Open Floor Meeting 1

Impact on businesses, including tourism

GREAT representing the villagers

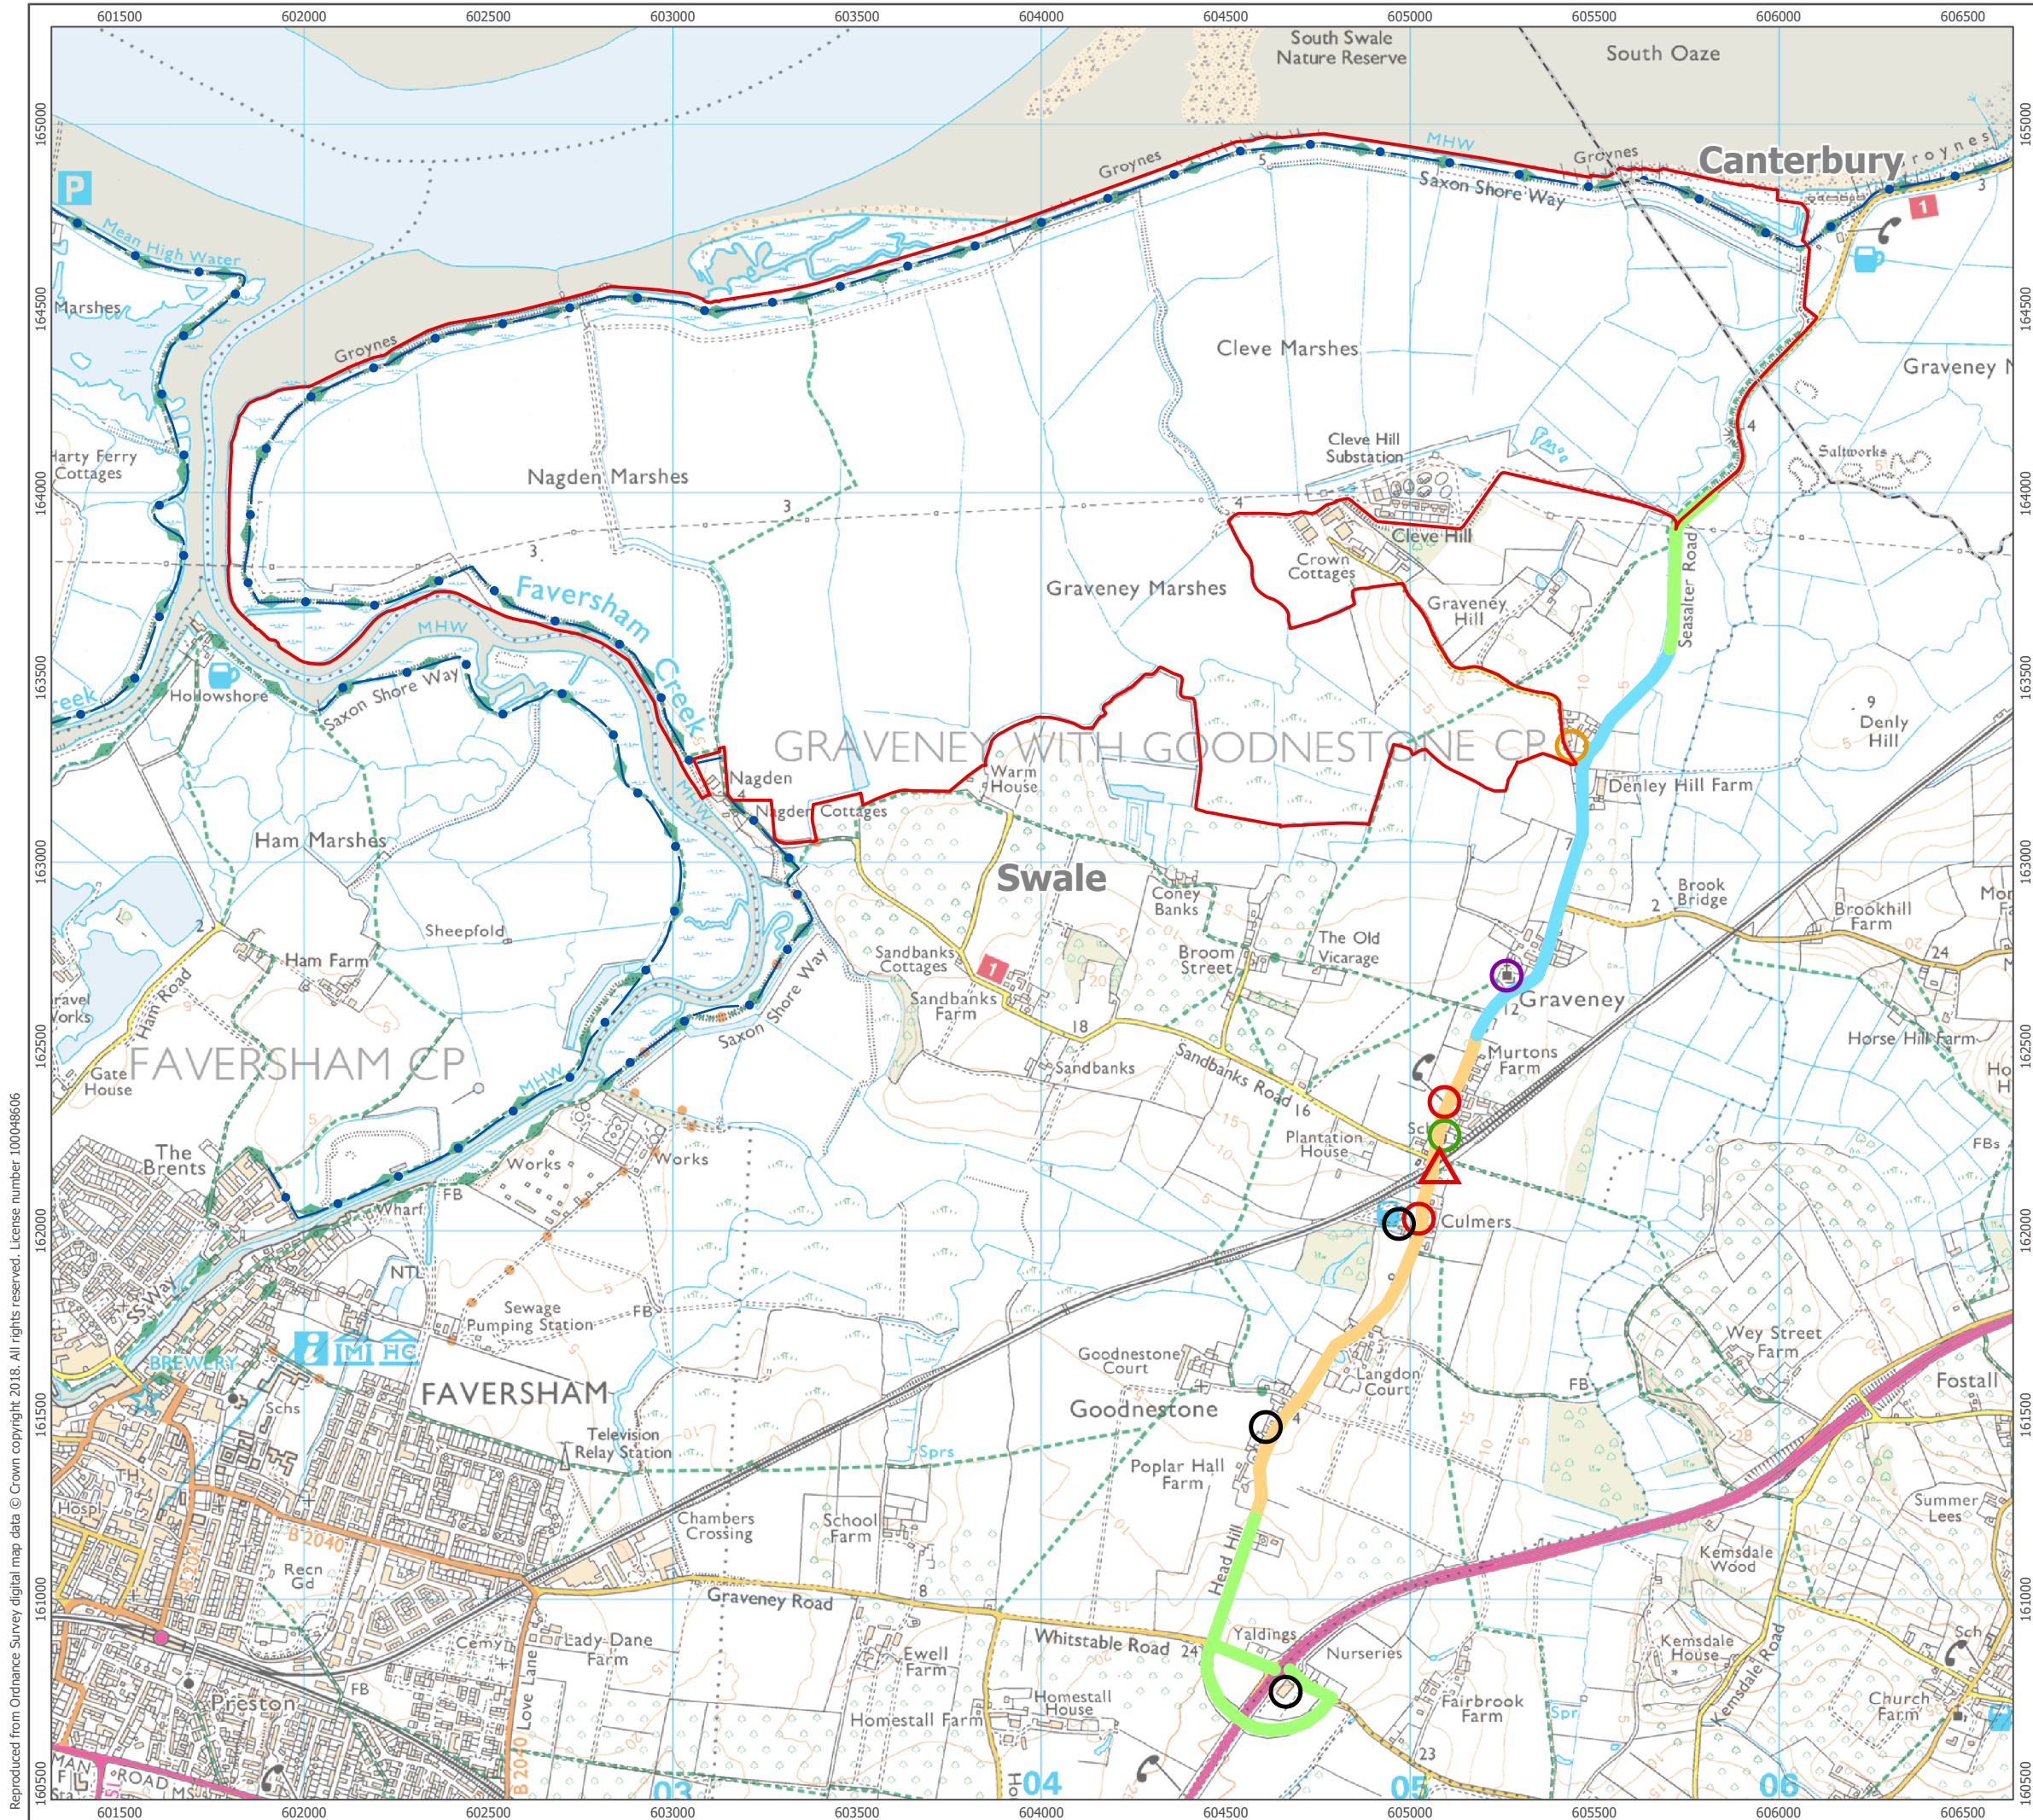
The primary route for traffic is from the top of Head Hill Road to the London Array substation access road - a distance of some 2 miles. The 'Sensitive Receptor' map produced by the applicants (Environment Statement Volume 2, Figures – Access and Traffic) identified just 6 receptors impacted by the development. Along this short distance there are actually 23 quite diverse local businesses that use this route (see map). They include a number of farms, a removal firm, a transport services company, the village school, two further educational care facilities, an equine centre, a holiday park, the Church, the village hall, London Array, National Grid and a skip company. All of these rely on good and unhindered access.

What has not been included on the applicants Sensitive Receptors map are the businesses beyond the London Array entrance which also use Headhill Road and Seasalter Road. This includes the Michelin star Sportsman restaurant, the Seasalter Chalet owners, Seasalter sailing club, Waldens shop, Forget Me Not café, Waldens caravan park, Alberta holiday park and the Oyster Pearl pub. Due to the low bridge in Seasalter all large vehicles bound for these businesses have to come through Graveney, including caravans being transported to and from the caravan parks.

The inaccuracy of the Sensitive Receptors map also includes a public telephone in the village that no longer exists. If the traffic

management plan is based on the applicant's incomplete and inaccurate information then the villagers should be given an explanation on who submitted this information, how it was obtained, and why it is so incomplete.
